DEVIATION REQUEST AND DECISION FORM

Drop Height

Project Name : Sterling Ranch Sand Creek Channel Construction Drawing Review CDR 20-4
 Schedule No.(s) : 5227301021, 5233309027, 5228000030 & 38, 5233301001 5233301016 &17
 Legal Description : See Exhibit B – Legal Description

A deviation from the standards of or in Section **ECM section 3.3.3 Open Channel Design Standards** of the Engineering Criteria Manual (ECM) is requested for the Sand Creek Channel Design – Low Flow Channel Capacity.

See Sheets 52-67 of the Sand Creek Restoration Construction Drawings
for further details and information

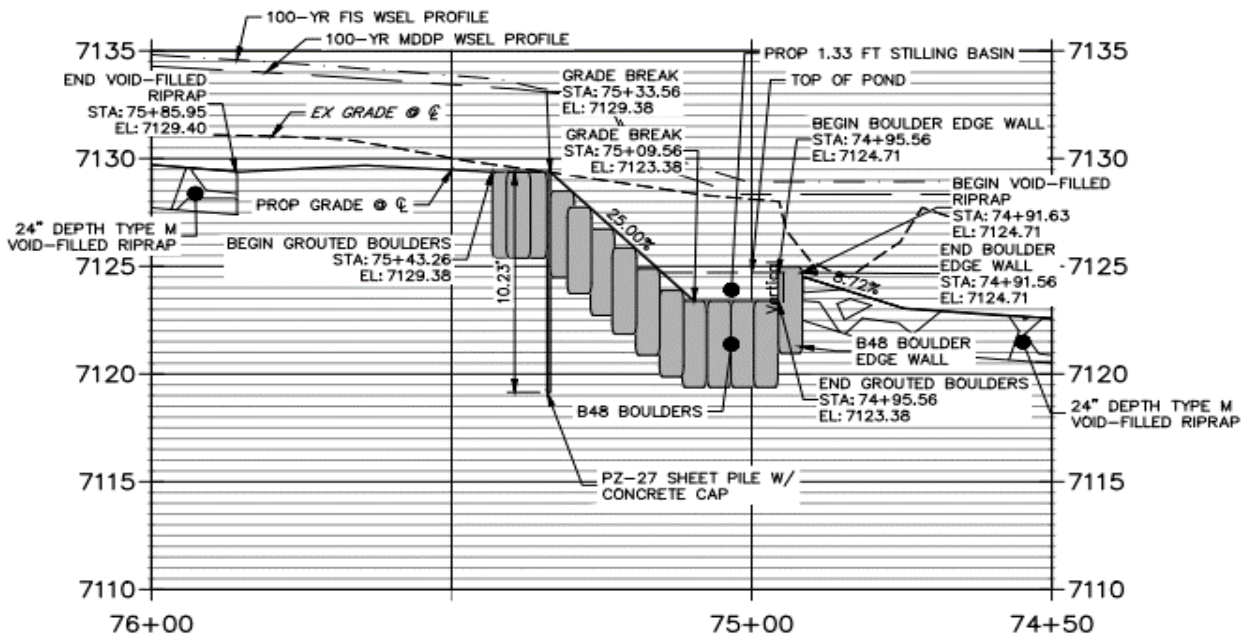
Per ECM Section 3.3.3 Item B. All open channels shall conform to DCM Volume 1 and Volume 2. Per DCM Vol. 1 chapter 6.5 Open Channel Design Criteria, Section 5 Drop Structures, drop structures are to be four feet or less in height.

Drop structures were placed strategically to reduce the amount of disturbance to the existing wetland corridor within the channel. Drop heights were also determined based upon wetland preservation which required some of the drop structures to exceed the four foot height criteria.

See Exhibit A for a table of the various drop heights used in the Sand Creek Channel plans along with a representative cross section of the general design.

In the design there are 8 grouted boulder drop structures. Seven are typically configured with crest, toe, stilling basin and sill wall and serve to reduce channel longitudinal slope thereby decreasing flow velocities. One drop (GSB #6) is used as a rundown into existing stock pond #2 in the reach above Briargate Parkway and the toe is below the existing water surface, therefore this drop does not require a sill wall.

Drop heights were sized to promote existing wetland preservation. Drop heights in this design are 6 feet or less when measured from crest to toe and 4.7 feet when measured from crest to sill wall of the stilling basin.

The ECM does allow for drop structure heights above four feet if supported by geotechnical investigations and appropriate measures are incorporated into the drop structure design to relieve hydrostatic groundwater pressure on the drop. Each of the 8 drop structures will have a sheet pile integrated into the crest of drop structure and will have a weep hole system to relieve hydrostatic groundwater pressure even regardless of height. .

This request has been determined to have met the criteria for approval. A deviation from Section 3.3.3 Item B. of the ECM is hereby granted based on the justification provided.
